Thurrock Flexible Generation Plant – responses to Natural England Response to Examining Authority’s Further Written Questions (REP5-026)

Date: 08/07/21
Regarding: Thurrock Flexible Generation Plant

Figure 1.1 Proposed causeway structure.

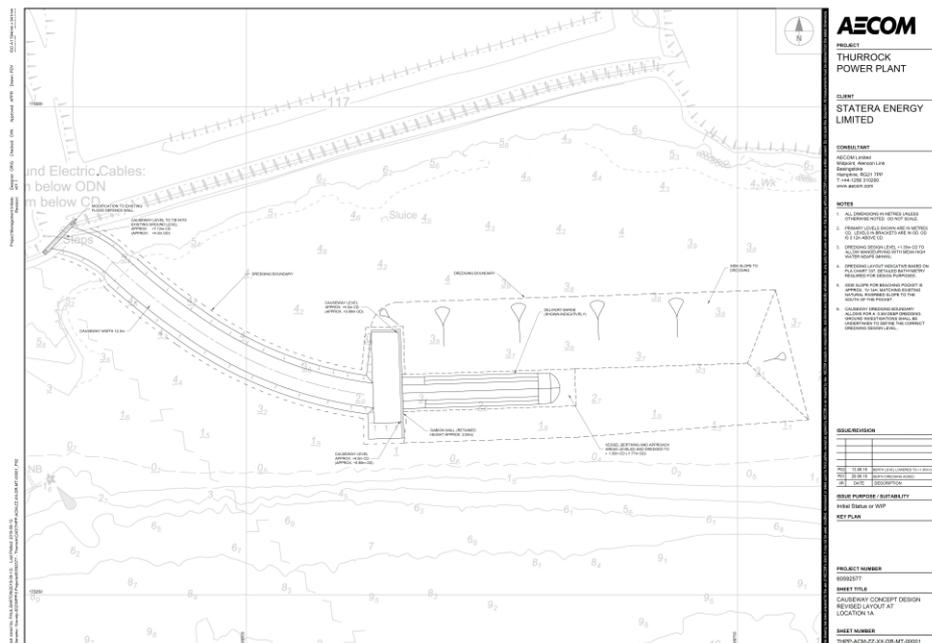
Subject	No.	Comment in REP5-027	TFGP response
Habitats Regulations Assessment	1	Whilst there is some uncertainty as to the precise area of direct habitat loss (accounting for incremental accretion over time from mudflat to saltmarsh), the area of habitat directly lost is not expected to be >1% of the available functionally linked land resource in this area of the estuary (including some on the south side of the river).	<p>The Applicant has provided additional clarification to NE of the areas of habitat loss in the additional analysis supplied with this response. In summary, direct habitat losses comprise:</p> <ul style="list-style-type: none"> • 0.38 ha of mudflat for the causeway (duration of impact: lifetime of causeway) • 1.42 ha of mudflat for dredging of barge pocket (duration of impact: approximately 2 years after barge deliveries cease, after which the barge pocket is expected to have recovered to mudflat) • 1.10 ha of mudflat for saltmarsh accretion (duration of impact: the 1.10 ha is the maximum amount of saltmarsh accretion that may occur over the 35-year lifetime of the causeway. Habitat loss would therefore start at zero when the causeway is constructed and increase gradually to 1.10 ha over the next 35 years). <p>Section 4.1 and Table 21 of the additional analysis submitted with this response demonstrates that direct habitat loss is <1% of the available mudflat resource regardless whether this impact is measured at a local scale (i.e. for Mucking Flats SSSI and FLL only) or at the full SPA level.</p>

4	<p>We have some concerns that 0 counts for qualifying species during the survey period may not be representative of typical usage (those species being generally found within the SPA / Ramsar site during the same period), and although we recognise that any survey is a sampling exercise, this may under-represent the bird usage of the area.</p>	<p>The bird surveys were based on standard accepted methodology for wintering foreshore bird surveys (two counts per month, one at high tide and one at low tide). Our calculations are all based on the highest counts recorded by surveys each month, and therefore it is reasonable to assume that zero counts within the impact area recorded during these surveys are representative.</p> <p>By sampling through the survey period and then choosing the highest monthly counts as the basis of our analysis, we are taking a more precautionary approach than using a simple mean value of counts across the whole survey period.</p> <p>Zero counts are part and parcel of that calculation; we consider them to be reflective of the use of that FLL outside the SPA, especially with reference to the other surveys reviewed in the HRAR (REP2-022), which in fact all recorded lower numbers of birds in the impact</p>

6	<p>The importance of inner estuary areas during severe weather means that a precautionary approach should be taken (noting that recent surveyed winters have been either average or milder and may not fully represent these conditions).</p>	<p>We refer to our previous responses on this matter (Ref. 1a in REP2-056 and Ref 2 in REP3-009):- while it is acknowledged that different parts of an estuary may provide habitat for birds associated with a SPA at different times depending on weather conditions, this general principle does not make it possible to quantify importance of the Functionally Linked Land during periods of severe weather at the project site in the absence of evidence that it is favoured by birds during periods of harsh weather conditions.</p> <p>Furthermore, in the event of severe weather conditions during the subsequent lifetime of its presence (i.e. when not in use), the causeway is extremely unlikely to displace waterbirds from the surrounding mudflats under such conditions when birds tend to be increasingly tolerant of active or passive disturbance.</p> <p>We would again note that Table 6.2 of the HRAR reviews surveys from two other wintering survey periods in addition to the surveys undertaken by the Applicant, both of which recorded birds at lower densities during those winters.</p>

7	<p>More fundamentally, if an alternative for delivery of AIL exists which is less harmful (which we understand from the Examination is the case), then this option should be selected as a preference. Such 'avoidance' is in line with the EIA and HRA assessment frameworks.</p>	<p>The Applicant is actively pursuing the alternative option and will update the Examination in due course.</p>
